TfNSW Reference: SYD21/00469/03

Client Reference: SSD-17352813

**EXHIBITION OF EIS - HUNTINGWOOD PROCESSING EXPANSION - 65
HUNTINGWOOD DRIVE, HUNTINGWOOD**

Figure 18 Temporary car parking during construction

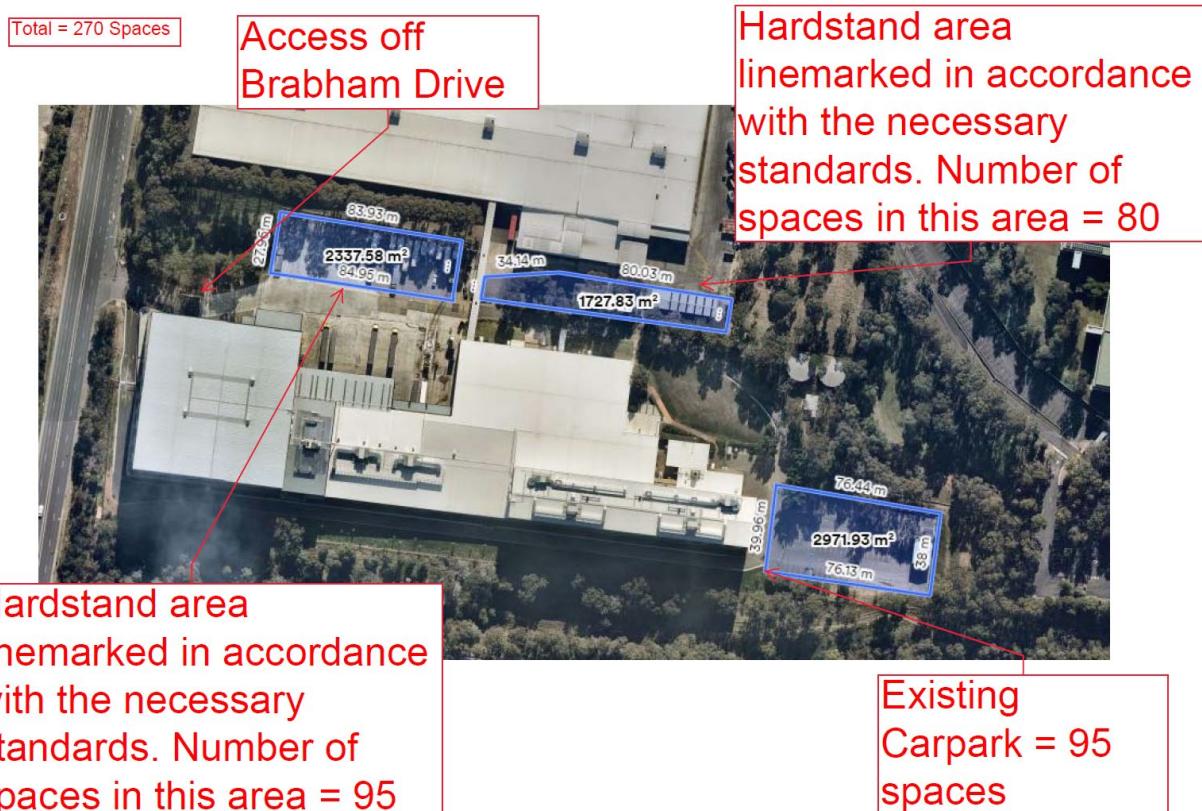
3. According to the construction staging plan, the existing staff car park would become unavailable during construction. Further parking study should be required to identify the potential parking shortfall during construction.
